Our Ref: 18COLL02: NVD/JT
SSD Ref: 9536
NSW RFS ref: D18/6890

**Re: Bushfire conditions
Wyong Hospital Expansion, Hamlyn Terrace**

Travers bushfire & Ecology are responding to the NSW Rural Fire Service (RFS) submission's made in relation to SSD 9536, and set out in its letter dated 4th March 2019, and in particular, Conditions 6, 7 & 8 which state the following:

**BUILDING ELEVATIONS - SHEET 1**

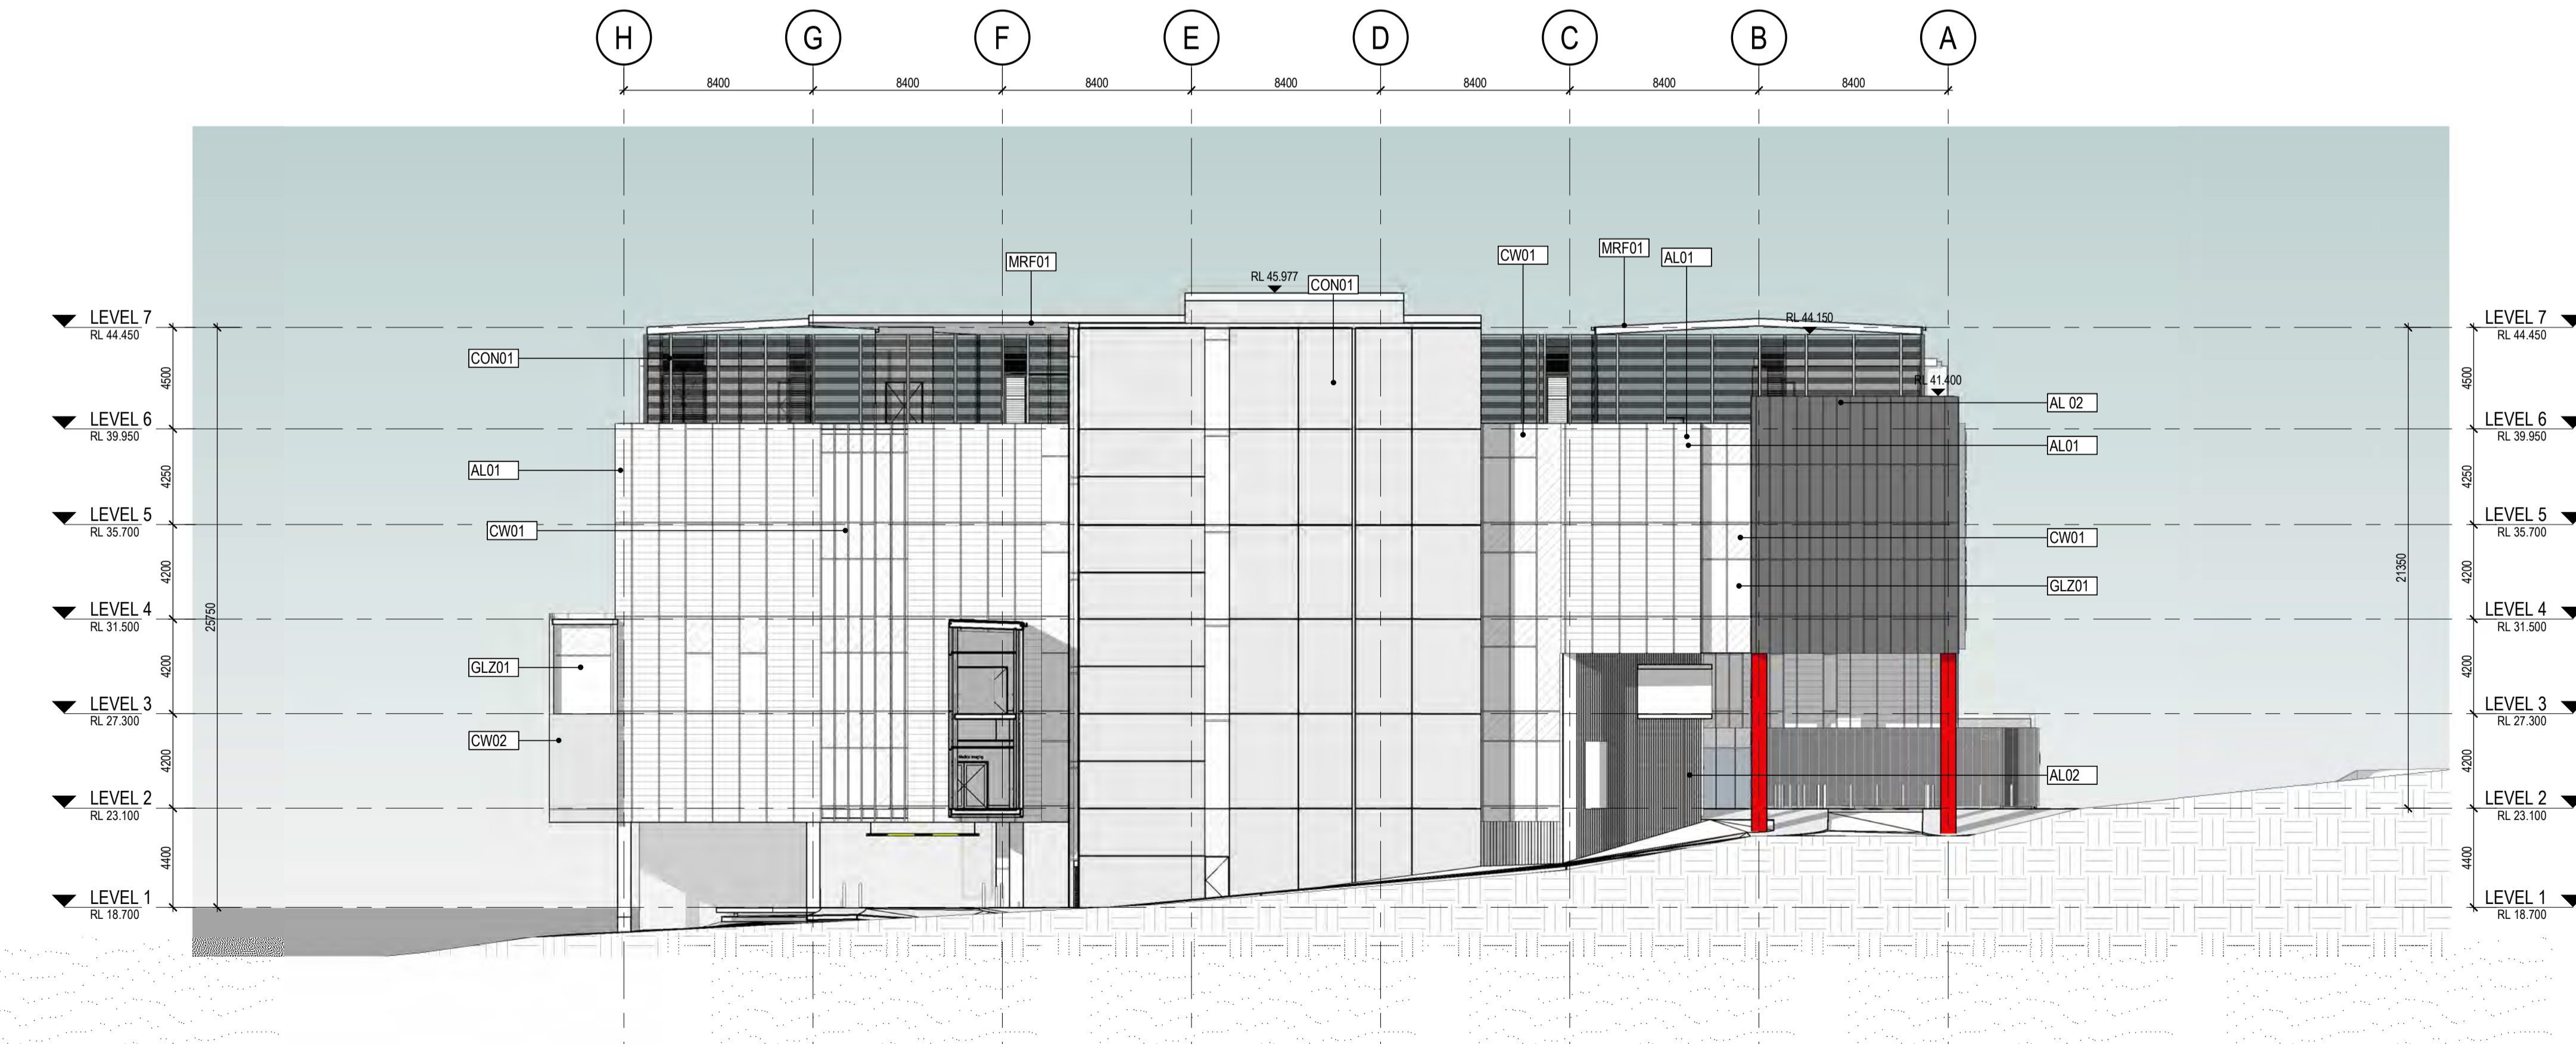
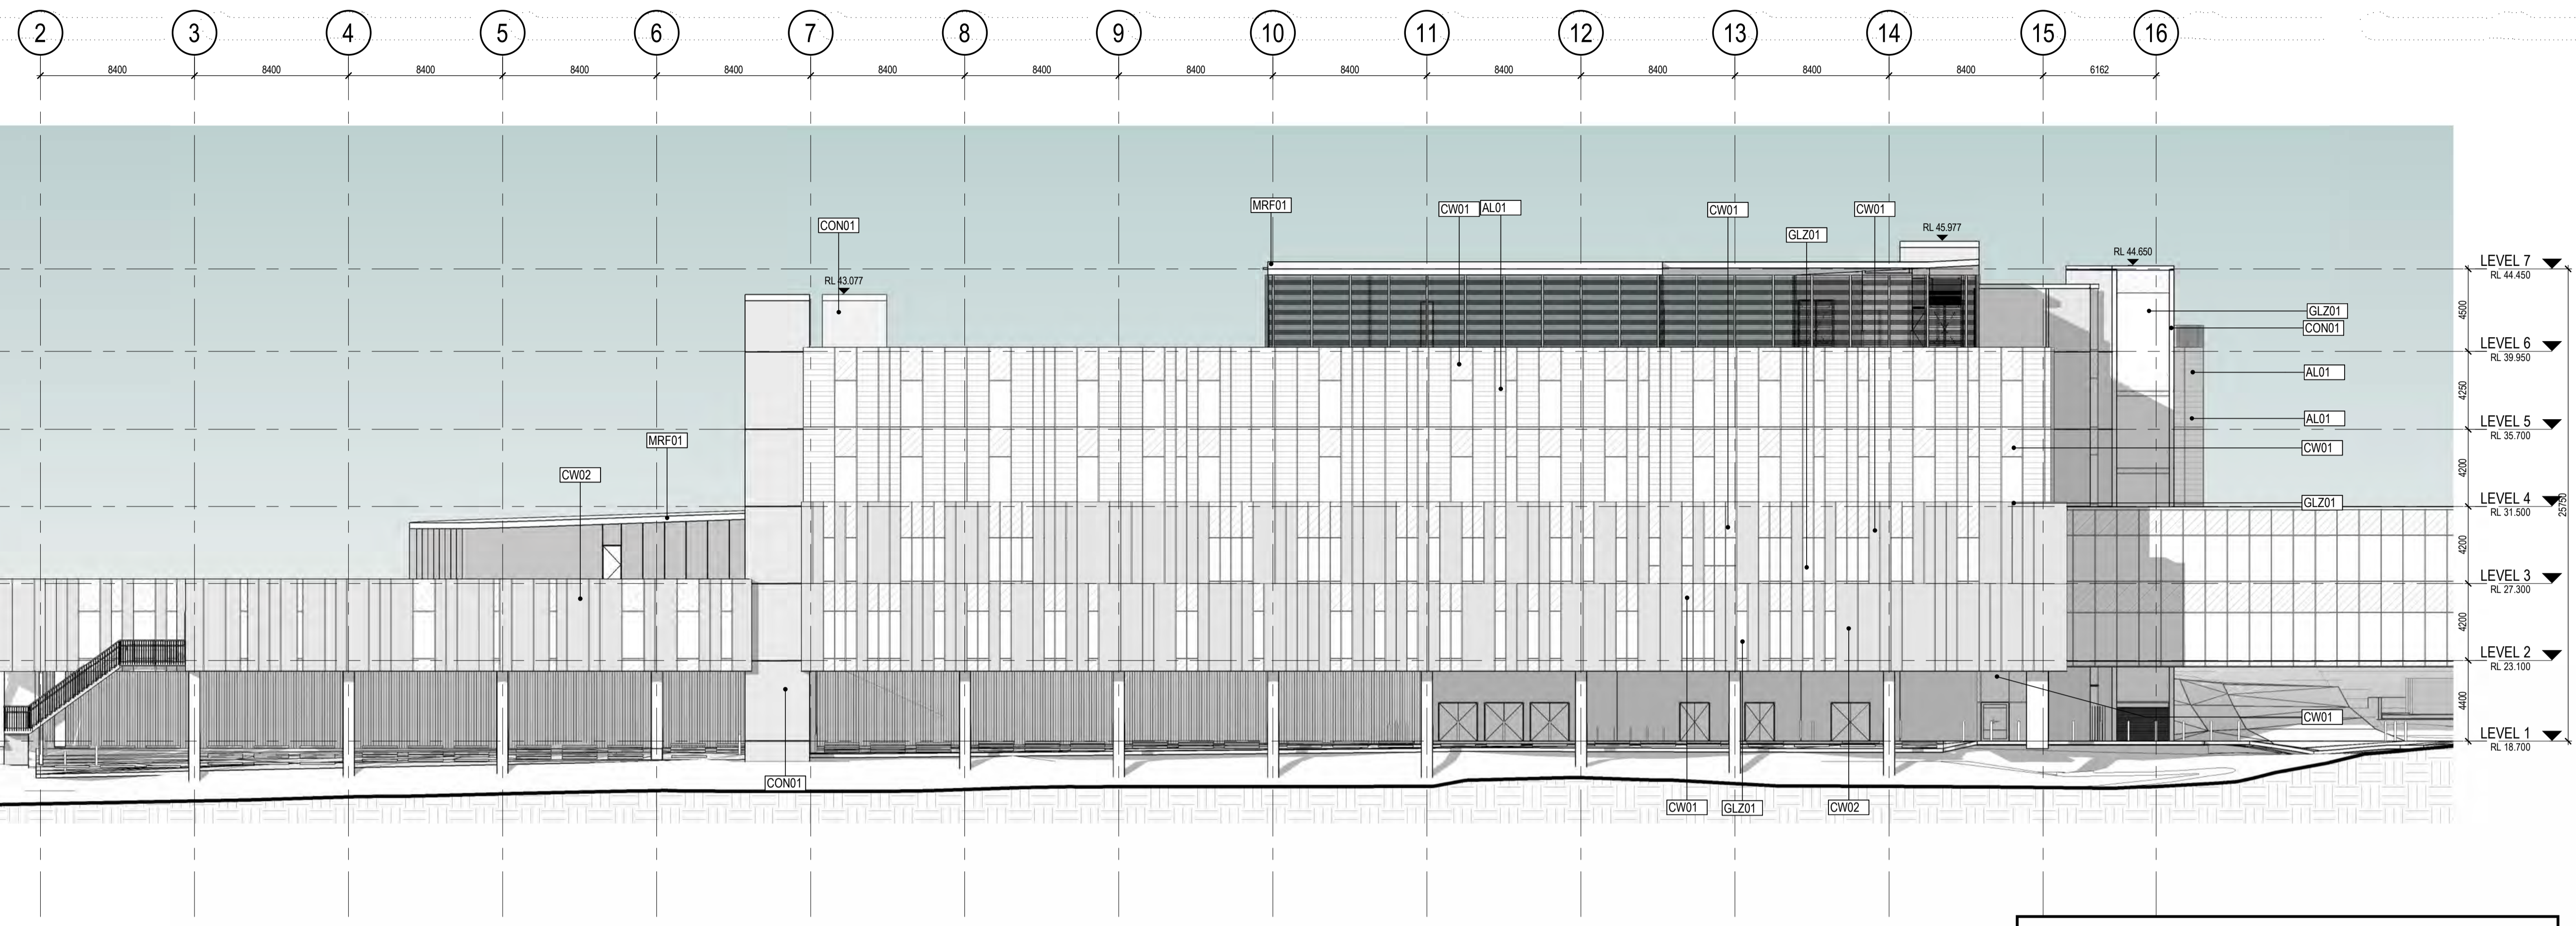
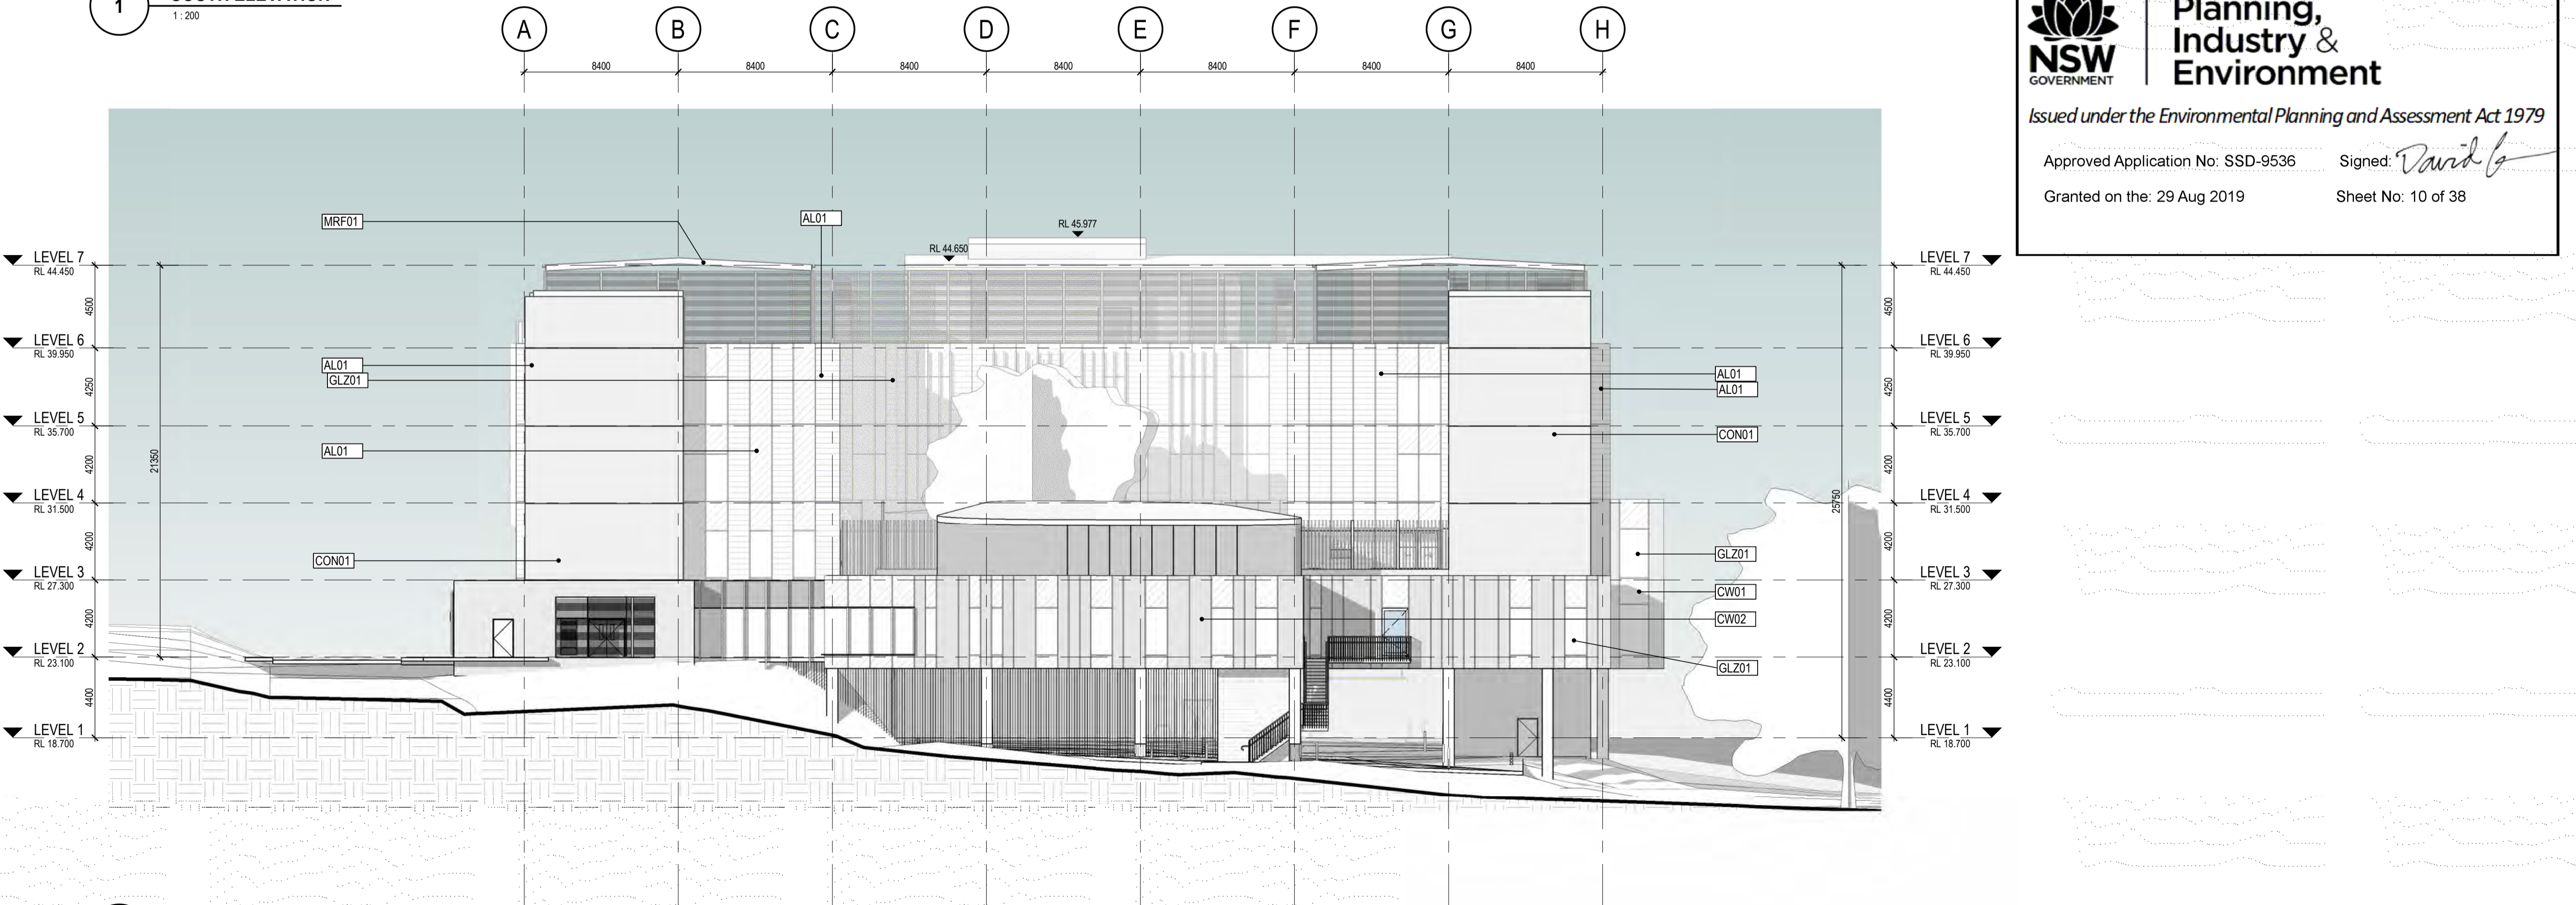
6. Construction of the roof, southern, eastern and western elevation(s) of the proposed works shall comply with section 3 and section 7 (BAL 29) Australian Standard AS3959-2009 Construction of buildings in bush fire-prone areas or NASH Standard (1.7.14 updated) National Standard Steel Framed Construction in Bushfire Areas – 2014 as appropriate and section A3.7 Addendum Appendix 3 of Planning for Bush Fire Protection 2006.

7. Construction of the northern elevation(s) of the proposed works shall comply with section 3 and section 6 (BAL 19) Australian Standard AS3959-2009 Construction of buildings in bush fire-prone areas or NASH Standard (1.7.14 updated) National Standard Steel Framed Construction in Bushfire Areas – 2014 as appropriate and section A3.7 Addendum Appendix 3 of Planning for Bush Fire Protection 2006.

The proposed building is being built closer to the unmanaged bushfire hazard vegetation than the existing buildings and a better bushfire outcome should be achieved and acknowledge the proximity of the proposed building to the hazard. This could be accomplished by an upgrade to the construction level of the western, southern, and eastern elevations and roofing to BAL 29 and a 1 level downgrade to the construction level of the northern elevation to BAL 19 for the shielded northern elevation should be considered.

As a result the NSW RFS have agreed (via telephone conversation 20/5/19) that Condition 8 can be removed and the requirement for the fence is no longer applicable. This is based on the increased building construction (in compliance with Condition 6 & 7) which will provide additional redundancy in the overall design. On this basis NSW Health accepts the recommended conditions 6 & 7.
